Please ask for: Sian Eggington
Email: sian.eggington@terraquest.co.uk
Telephone: 0121 2341390
Our Ref: LU/330/20/PL
Your Ref:
Date: 4th December 2020

Application for Planning Permission

Development: Replace existing side window with new door with Juliet balcony
Location: Lakeview, Flat 7 Hendon Avenue Littlehampton BN16 2LX

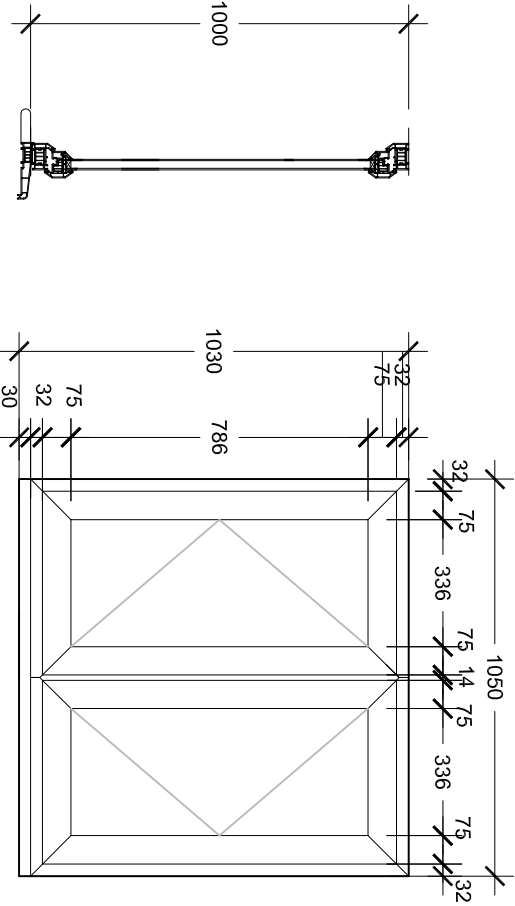
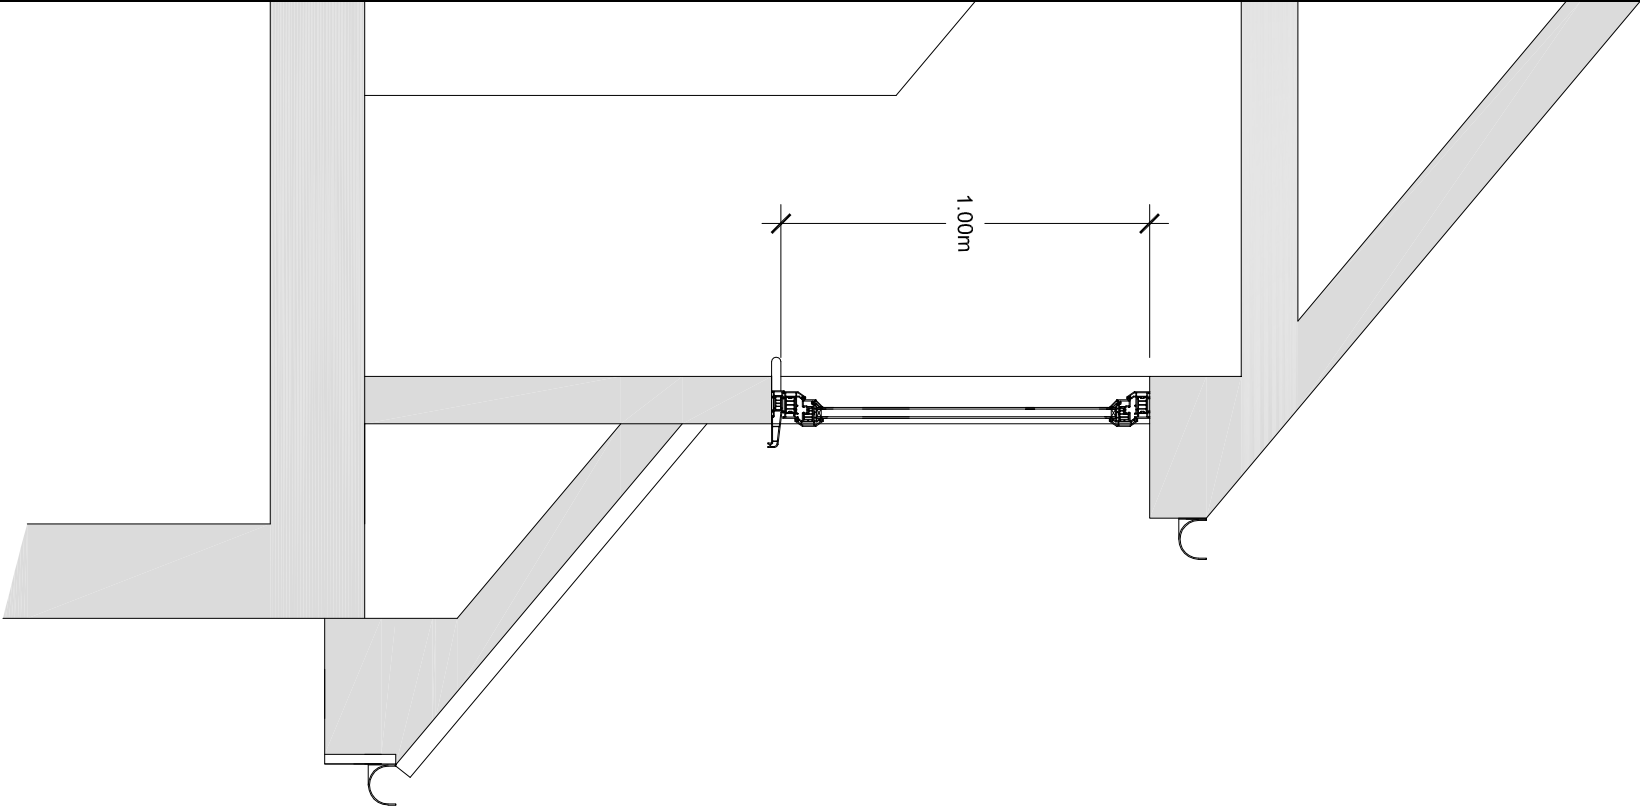
Please submit 1 electronic copy of clearly labelled existing and proposed elevations at a scale of 1:50 or 1:100. Further details can be found in the Validation Requirements List.

Revision	Date	Description
Client:		
Mr & Mrs B Lane, 7 Lakeview, Hendon Avenue, BN16 2LX		
Project:		
Replacement window		
Drawing Title:		
Site and Location Plans		
Scale:	Date:	Drawn By:
Noted	25/11/2020	BE
Drawing Number:		Revision:
1407/001		A

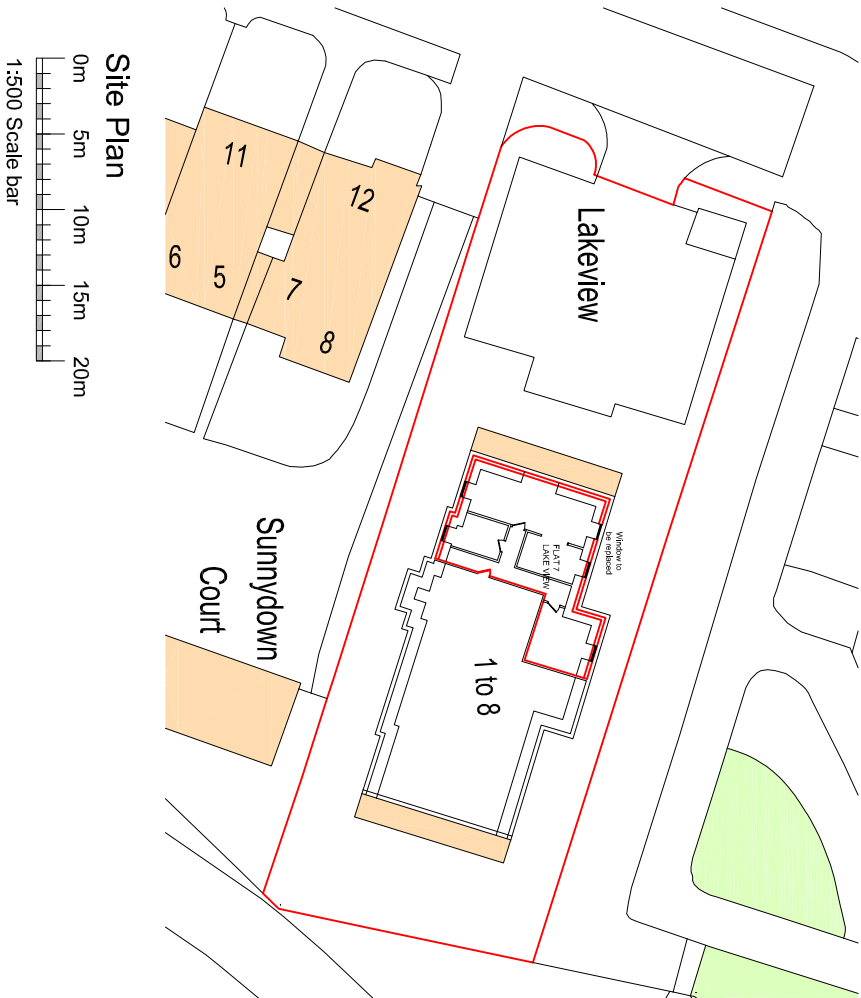
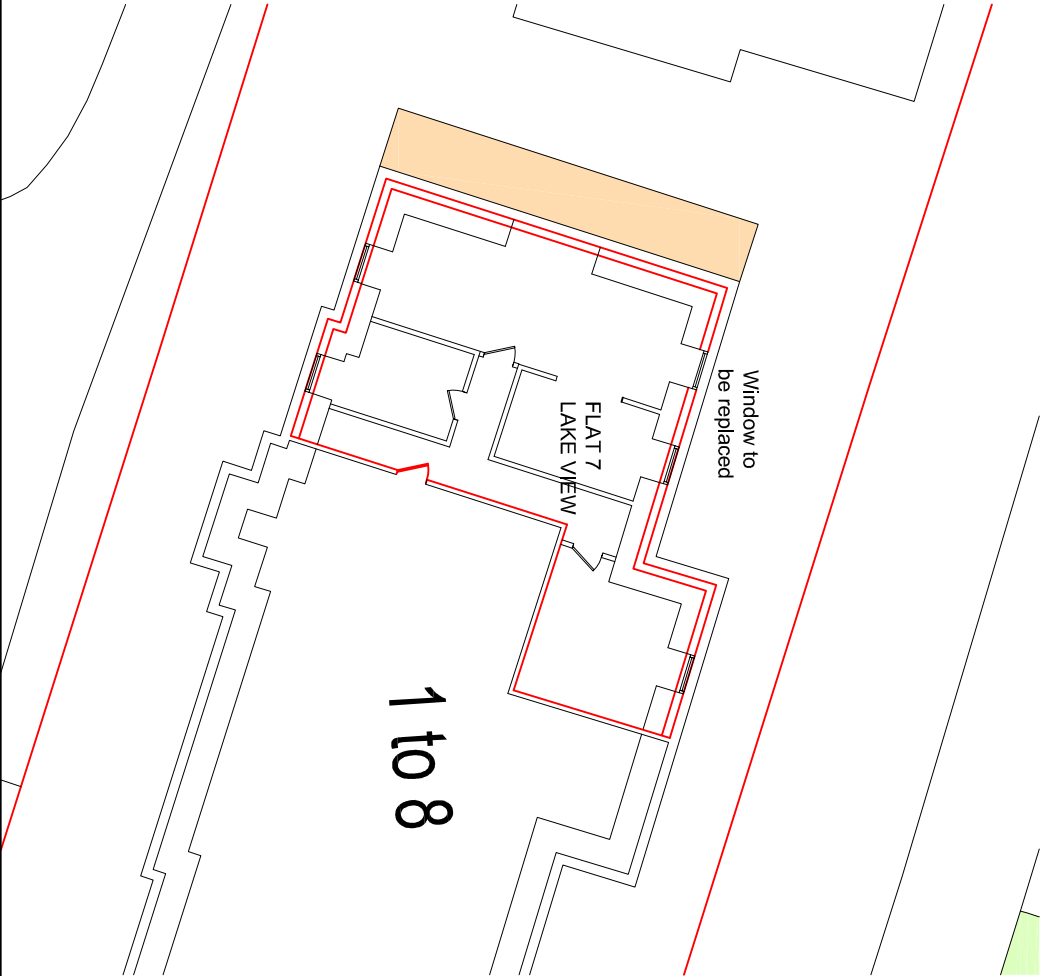
Please include the entire site and access in the red outline. Please also update your block plan to match this new red outline on the Location Plan. Further details of what must be included on the plan can be found in the Validation Requirements List.
